WEST SUSSEX COUNTY COUNCIL CONSULTATION

TO:	Arun District Council FAO: Michael Eastham
FROM:	WSSC – Lead Local Flood Authority
DATE:	27 th September 2019
LOCATION:	Bridge Cottage Lidsey Road Bognor Regis PO22 9PH
SUBJECT:	AL/75/19/PL Construction of 8 no. dwellings, alterations to access and associated works
RECOMMENDATION:	Advice – No objection

Figure 4 Surface Water Flooding Map

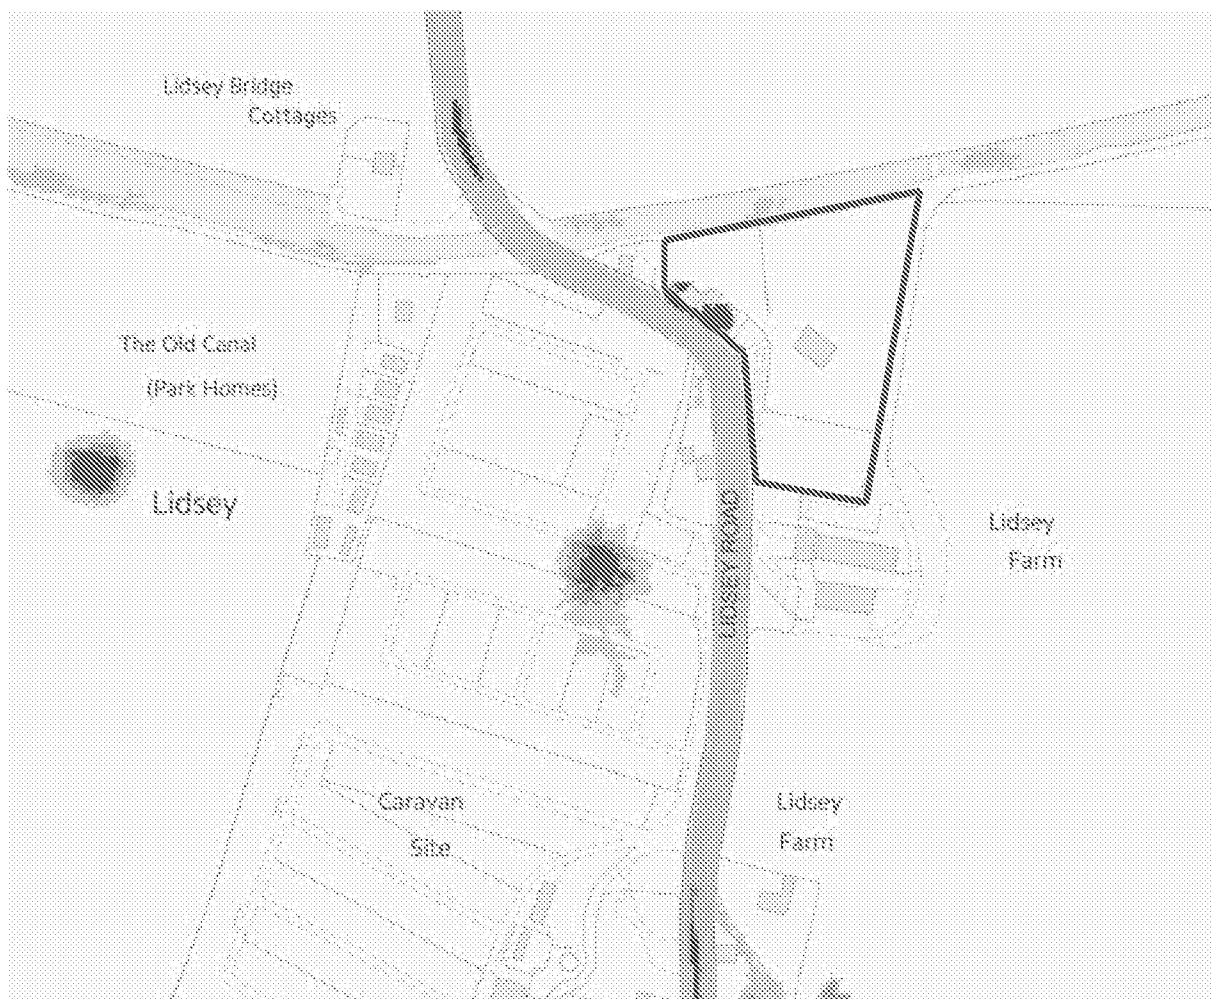
Current surface water flood risk based on 30year and 100year events	Low risk
Comments: Current surface water mapping shows that the majority of the proposed site is at low risk from surface water flooding although there is a small area in the north-west section of the site which is a higher risk. This risk is based on modelled data only and should not be taken as meaning that the site will/will not definitely flood in these events. Any existing surface water flow paths across the site should be maintained and mitigation measures proposed for areas at high risk. Reason: NPPF paragraph 163 states – ‘When determining any planning application, local planning authorities should ensure flood risk is not increased elsewhere.’
